Application No: CM/70/21/PL
Site Address: Land at Wren Cottage Horsemere Green Lane Climping BN17 5QZ
Description of works: Subdivision of the plot and construction of 3 detached bungalows with associated parking, access and landscaping (resubmission of CM/17/21/PL). This application is in CIL Zone 3 and is CIL Liable as new dwellings.

Thank you for your internet representation made on 8th December 2021 which has been recorded as an objection with the comments as follows:

Title
Location & Block Plan

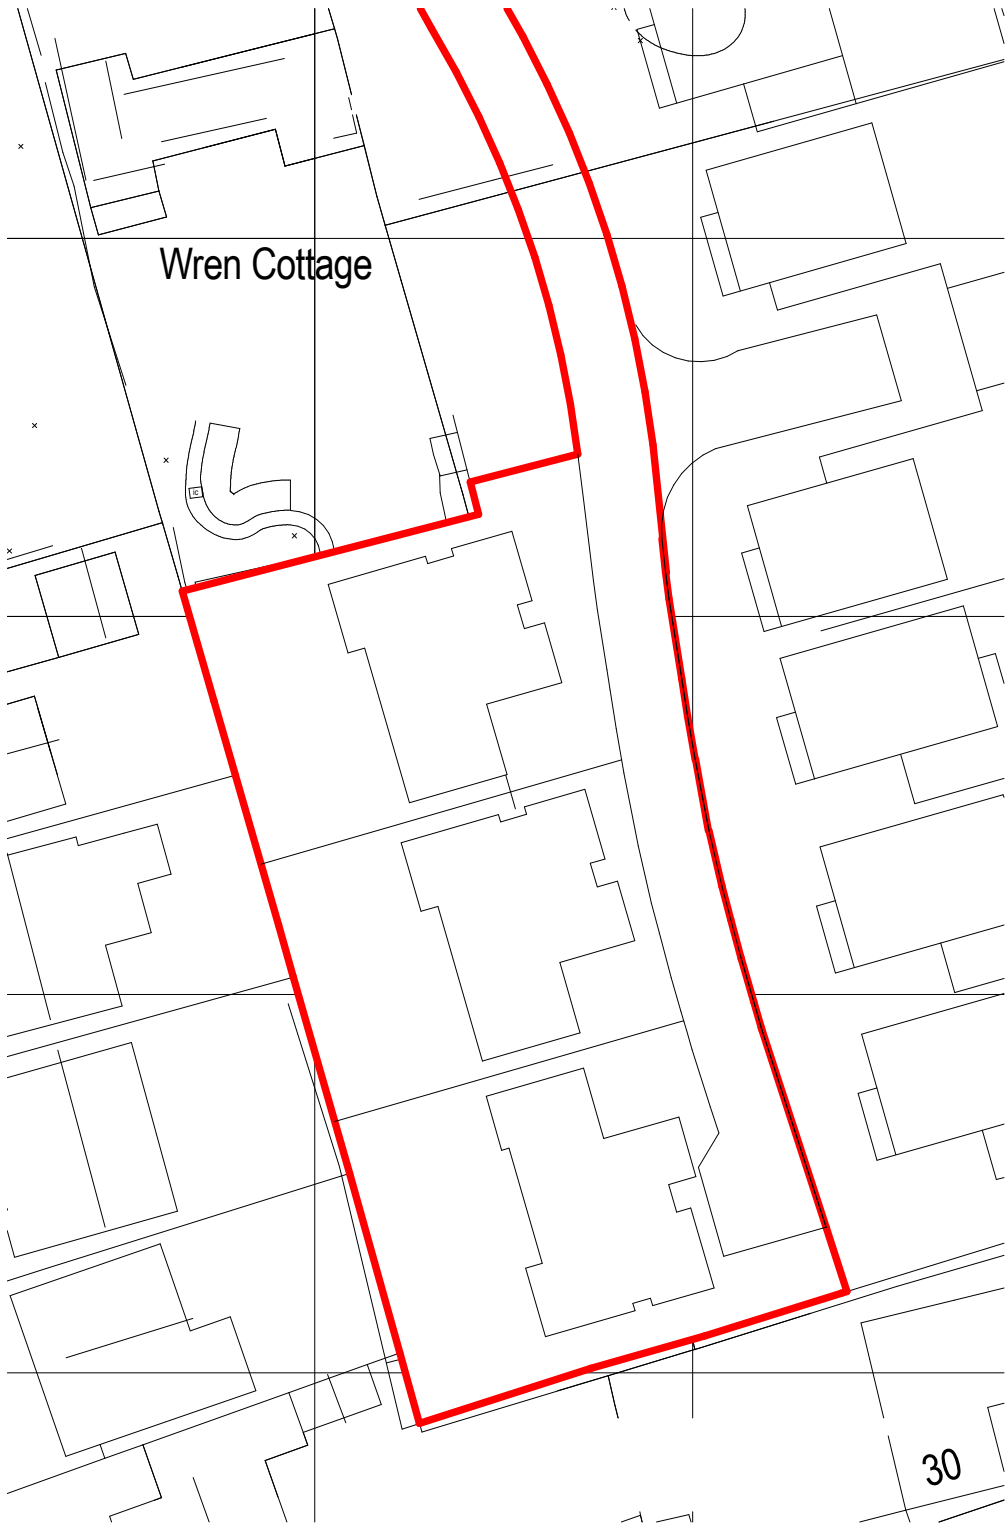
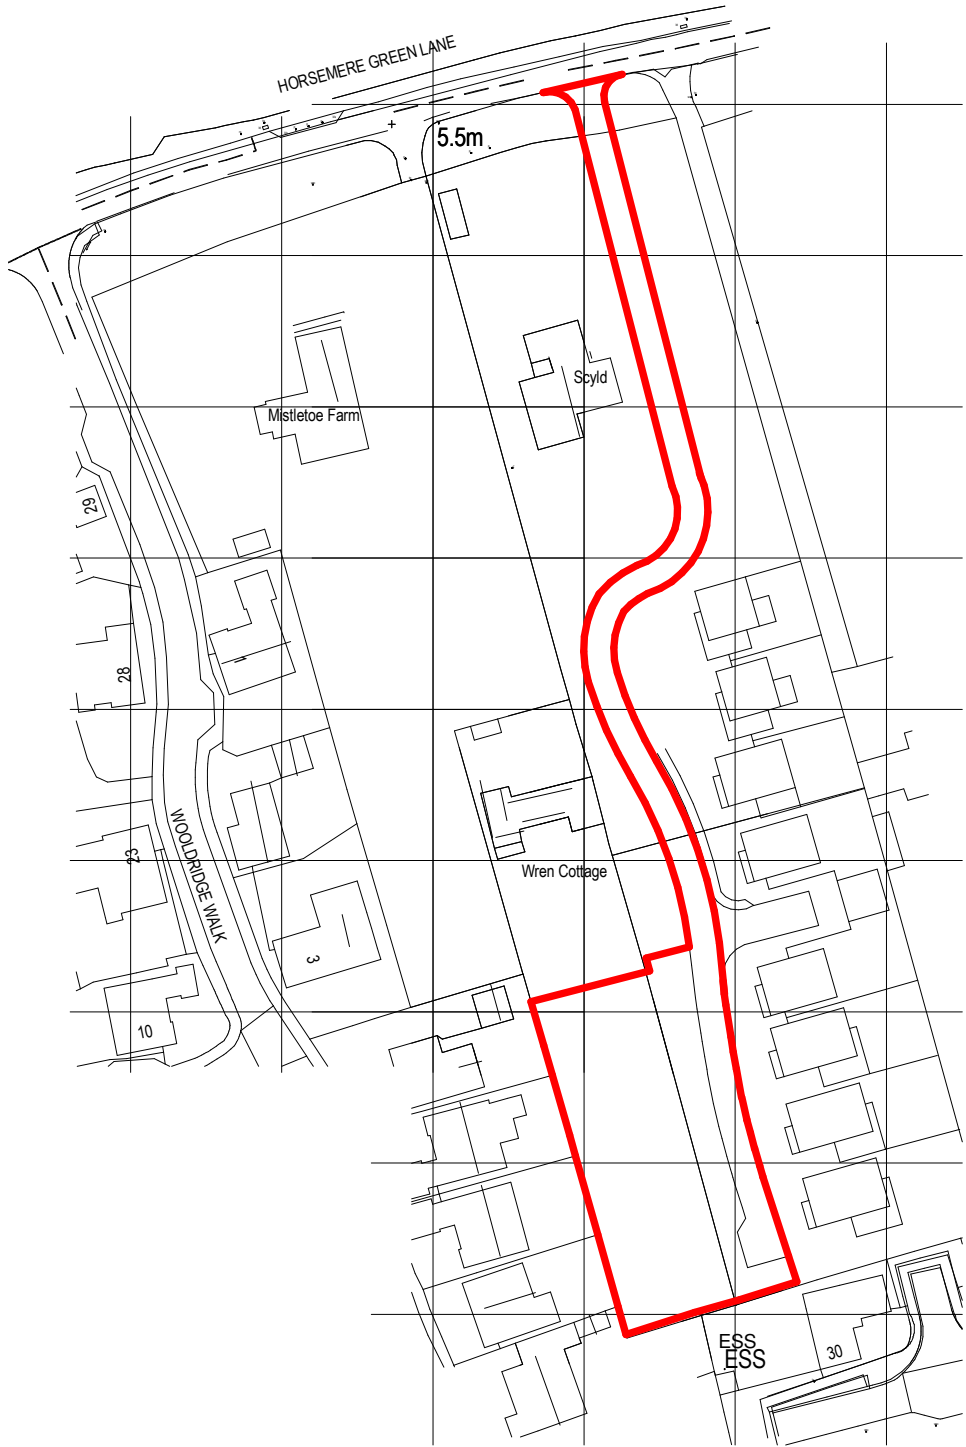
On looking at these revised plans it seems clear that the planned area for this development has not changed from the previous plans except that they have been changed from two storey dwellings to single storey dwellings bearing in mind that a three bedroom bungalow will require a greater minimum garden size (about 60-70 sq ft) to accommodate 3 bedrooms.

Therefore in my view as the proposed plans stand, the back to back proposed plan would not ensure standard requirements

for the development or a layout and design that provides standards of privacy and outlook for both existing and proposed residents. Our previous discussions on site with Neil Crowther (prior to planning refusal) he confirmed that the size of the proposed plots did not meet the standard building requirements and feel these have not changed therefore 2 bedroom dwellings rather than 3 bedroom would be more in keeping with the plot size.

We probably will lose the privacy of our garden space and any outside activities in our garden might be under threat by inadequate garden space by a proposed cramped back to back development. Also I would like to mention that any potential extension or any outbuilding (for example garden office or conservatory) if considered would bring the whole development even closer to my property.

Therefore, in summing up please consider all my above comments regarding the back to back measurements and privacy and give some thought at this planning stage to avoid future possible problems.
